REPORT UPDATE

Application No: EP/90/09/

PLANNING APPLICATION REPORT**REF NO:** EP/90/09/**LOCATION:** Churchfield
Station Road
East Preston**PROPOSAL:** Demolition of existing buildings & residential redevelopment to provide 14 no. houses & apartments, with associated parking & open space.**SITE AND SURROUNDINGS**

Section Profile - Plots 6 - 10

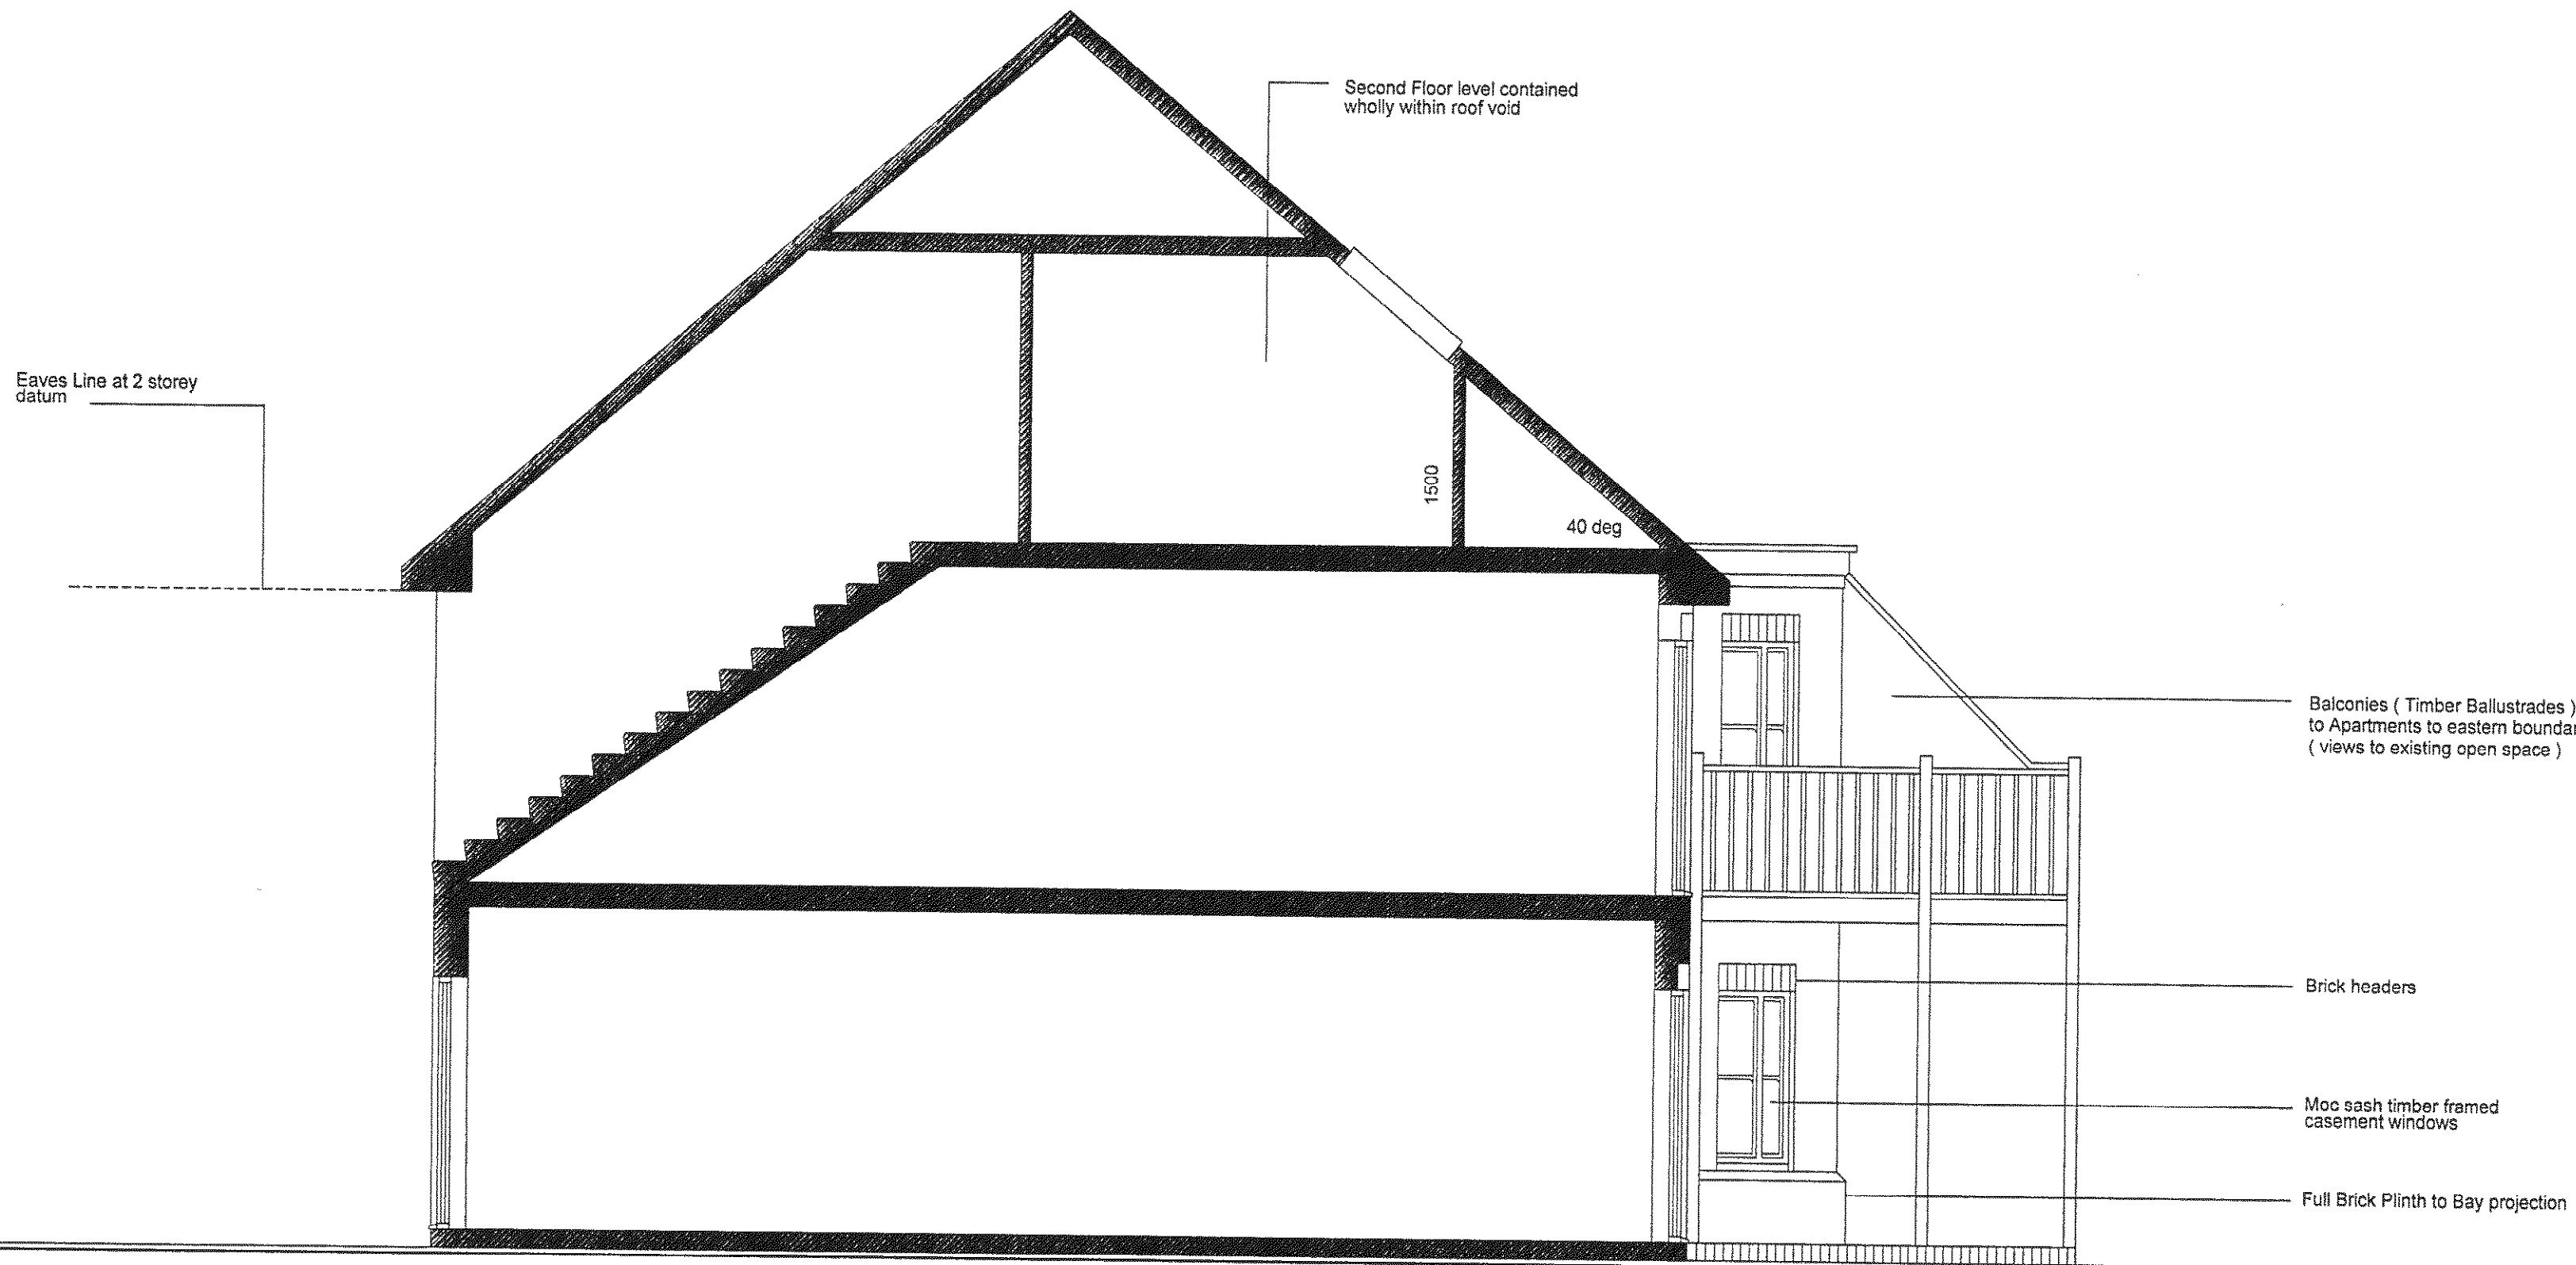
Amended elevational plans have been received which delete the balcony to the 2nd floor of the flats; delete the dormers and doors which were associated with this balcony on the 2nd floor; removed the 2nd floor built link section between the terraced housing and the flats.

The amended elevations are acceptable design changes brought about following discussions with the LPA.
